Approval of details reserved by condition imposed under ref BE/103/19/RES relating to Condition Nos 5 - footpath link to Winston Crescent and 9 - materials and finishes.

Rookery Park Land west of New Barn Lane Bersted PO21 5DN

Arun District Council have decided to **REFUSE details reserved by condition for the following reasons:**

TITLE: S278 PAVEMENT & KERBING PLAN

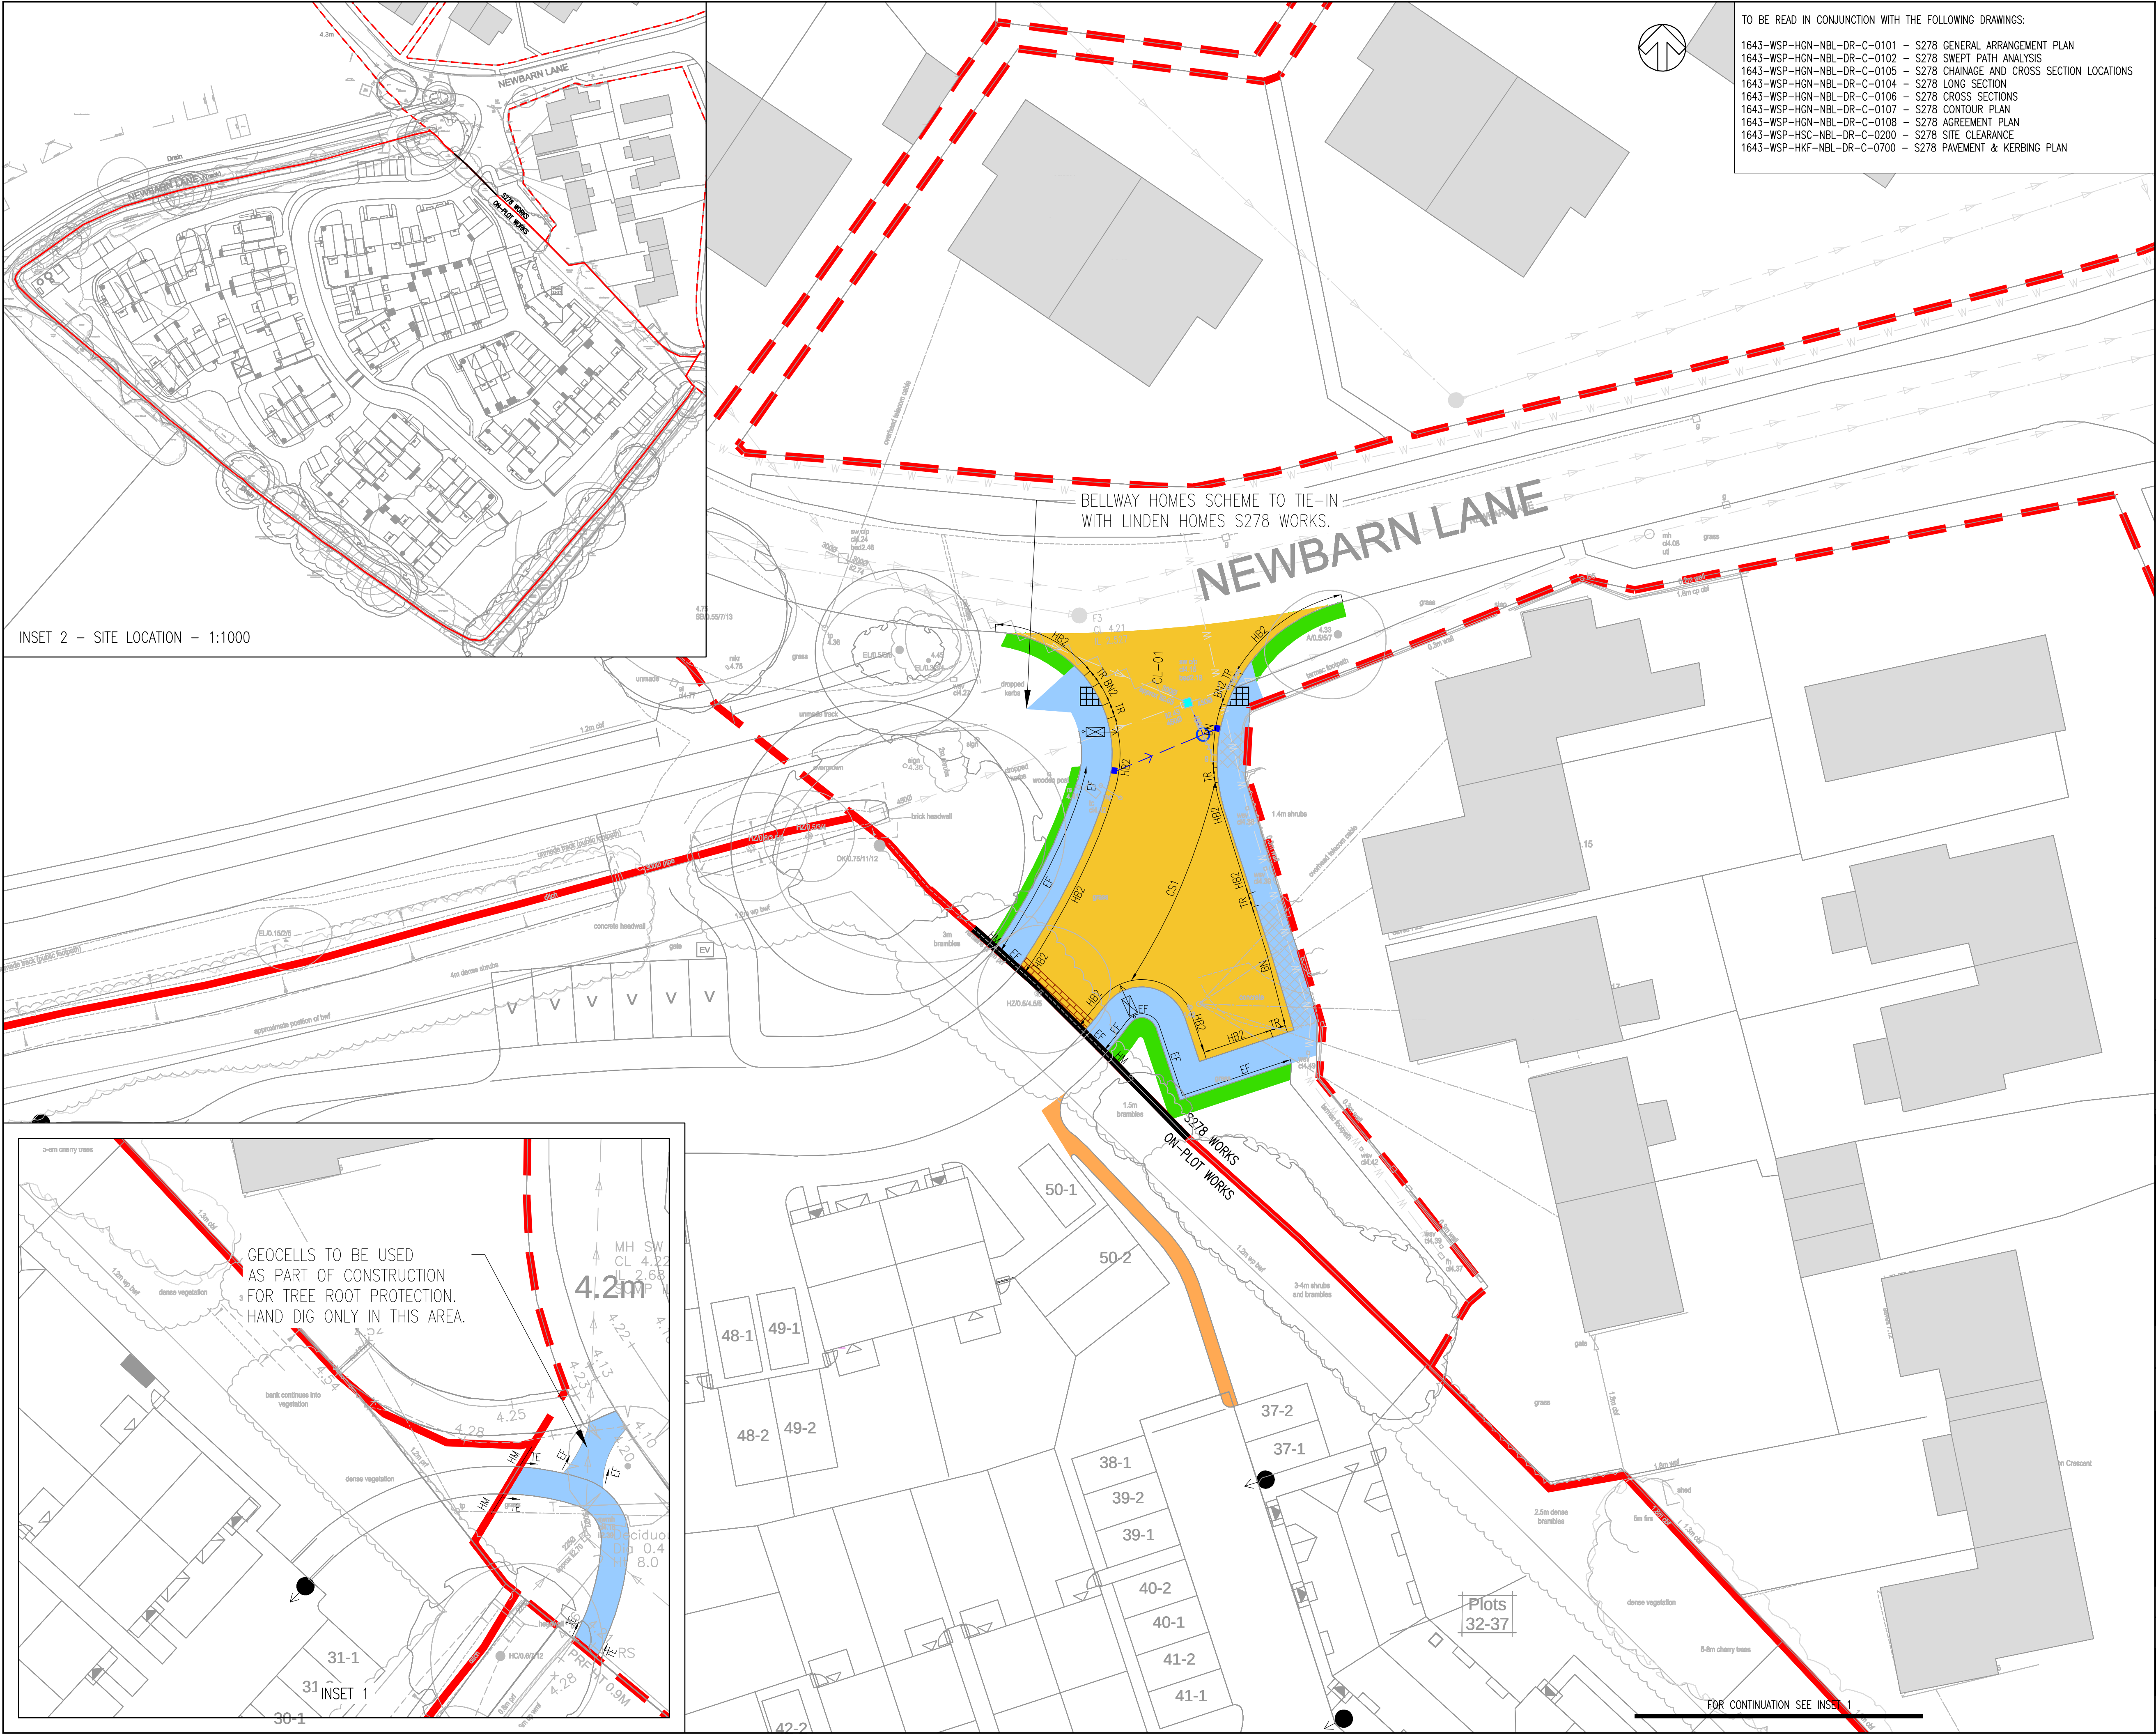
Insufficient information has been provided. The condition requires the submission of full details of the proposed footpath, including a timetable for construction. On 11 September 2020 and 14 October 2020, the local planning authority requested:

1. The timetable for construction;
2. The arboricultural advice that was obtained; and
3. Surface and edging details for the proposed length of footpath between the highway boundary and where it joins the compacted gravel hoggin path shown on the approved drawing numbered 18256 P105 A.

The information has not been provided.
